Sydney Olympic Park New High School

Architectural Response to SDRP Report

Authority: State Design Review Panel

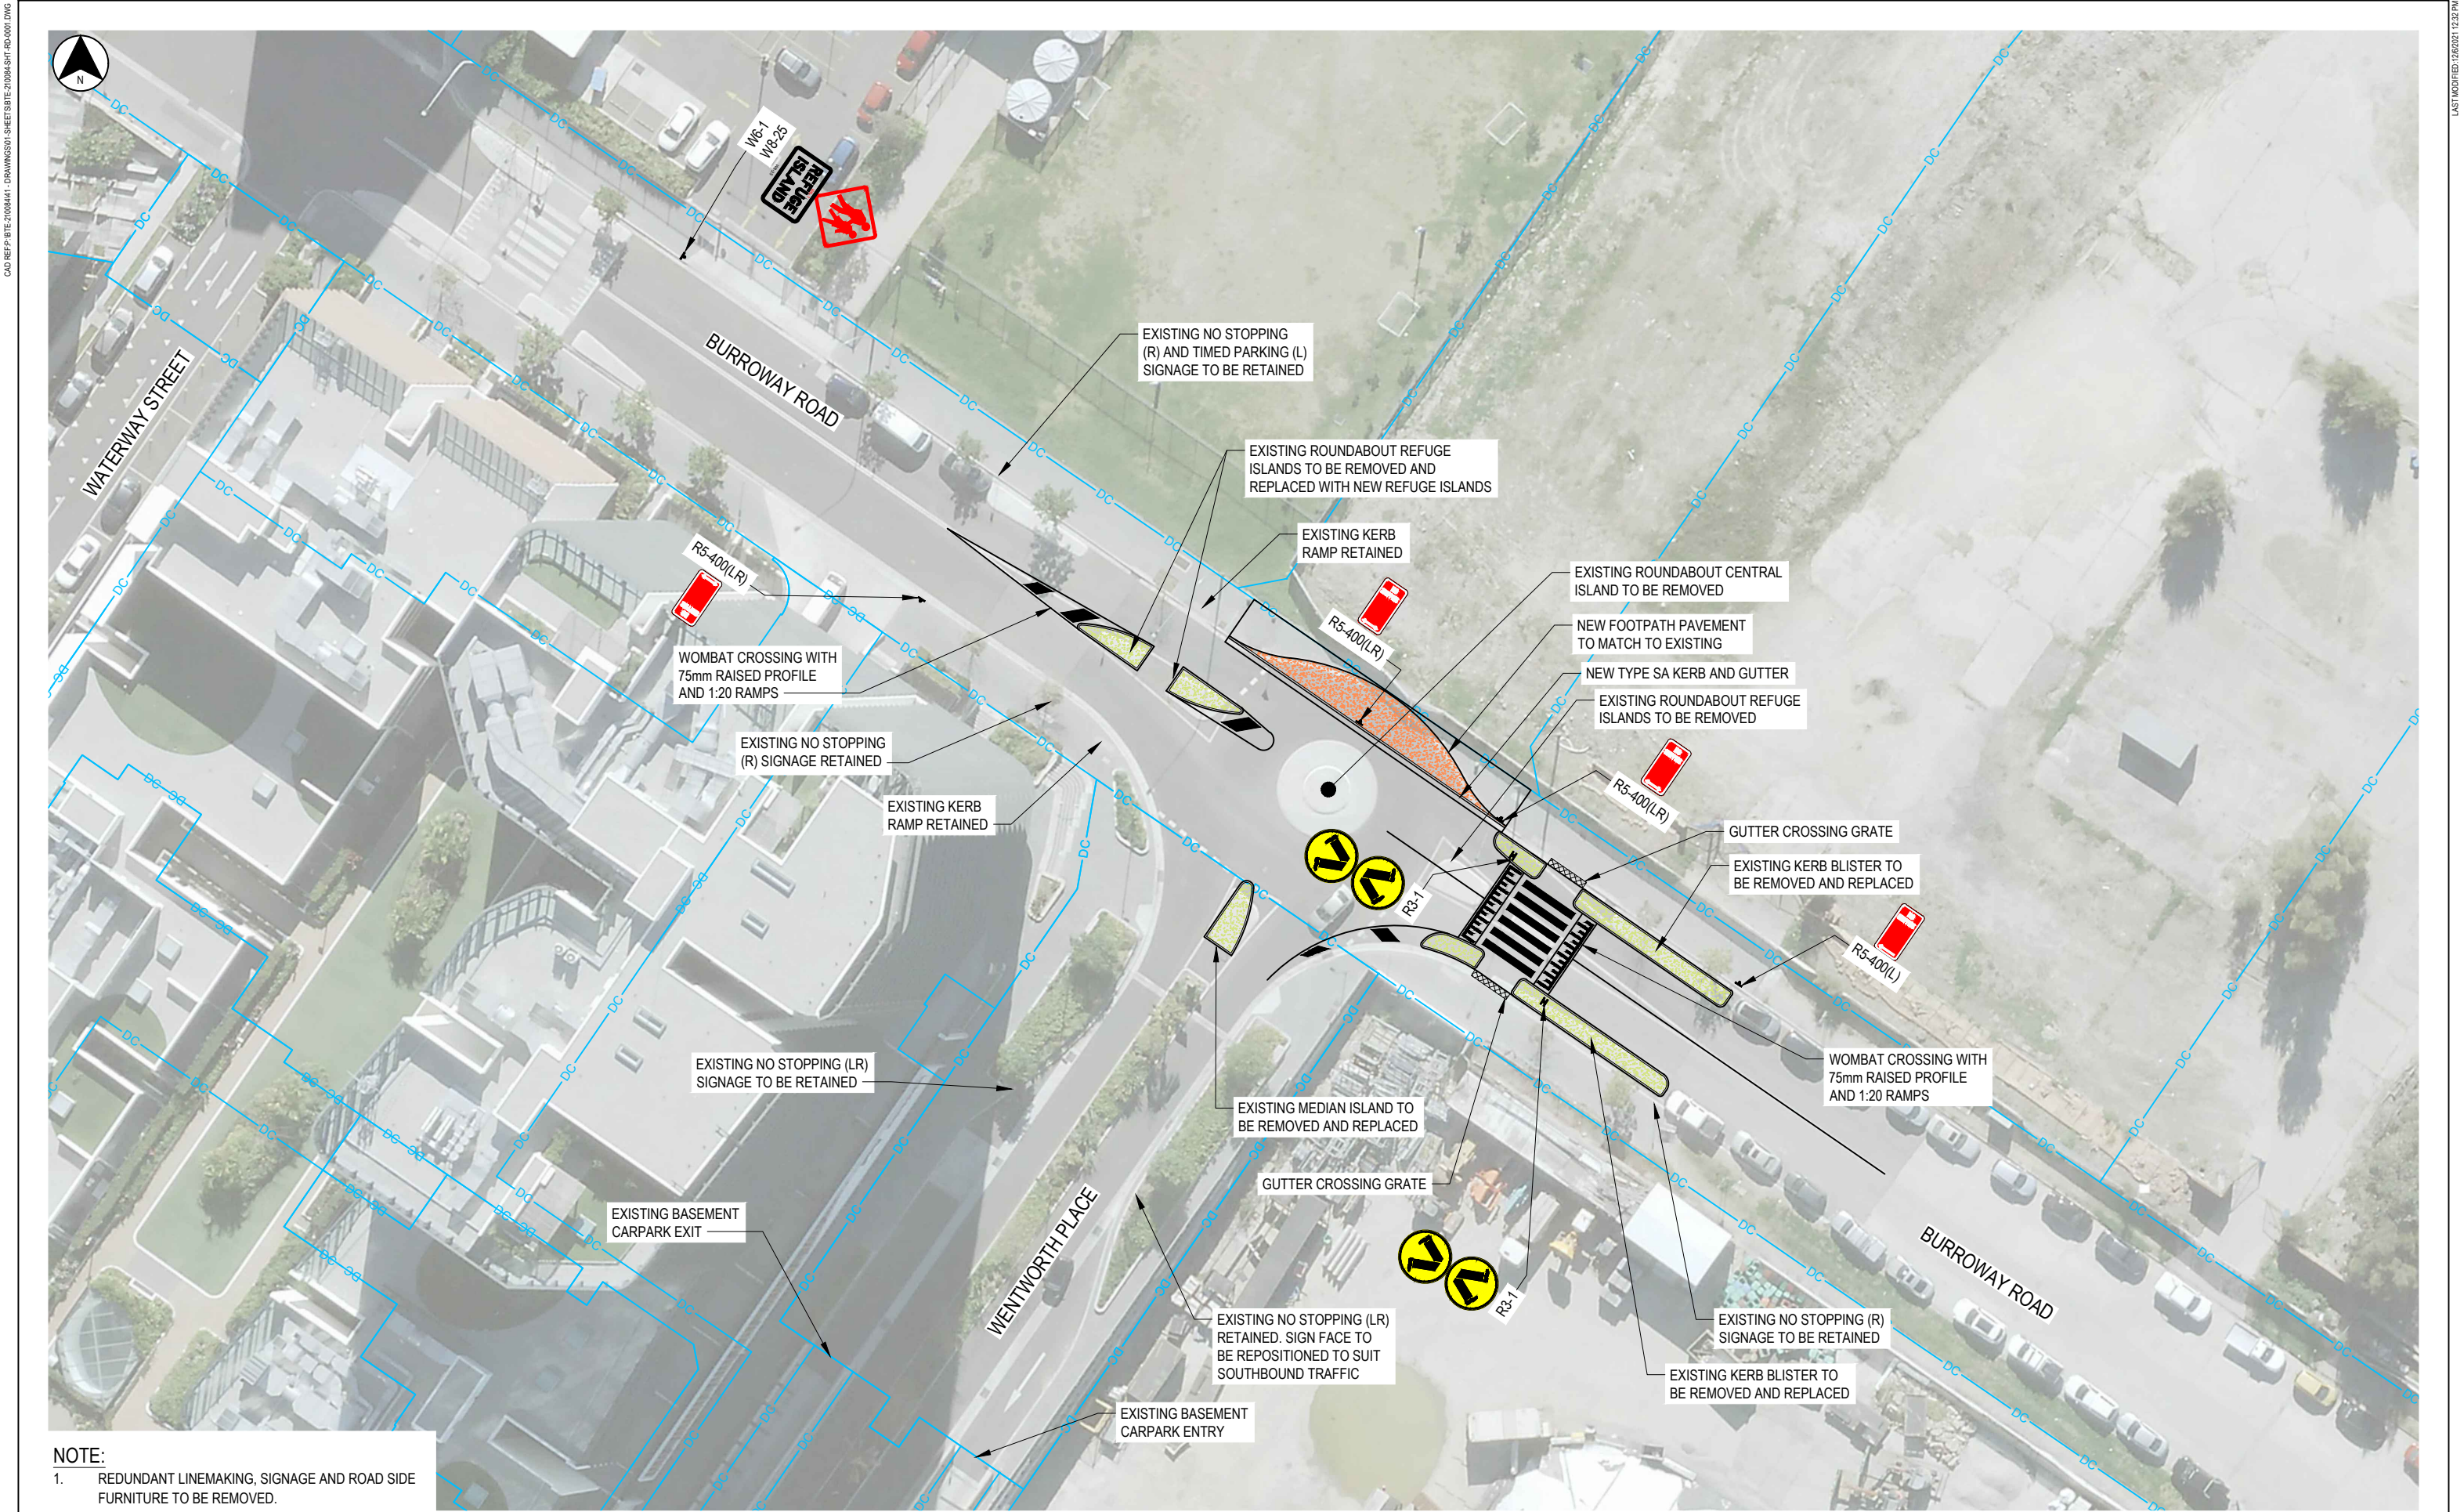
Comment: Footpath width – The footpath at the roundabout on Burroway Road is too narrow and poses a safety risk. Confirm resolution of this area to enable shared access for cyclists and pedestrians during peak periods.

The roundabout at the intersection of Burroway Rd and Wentworth Place will be replaced by a give-way T-intersection. The footpath will be infilled at the intersection, creating a continuous footpath approximately 3-4m in width, matching the line of existing kerbs to the east and west of the intersection.
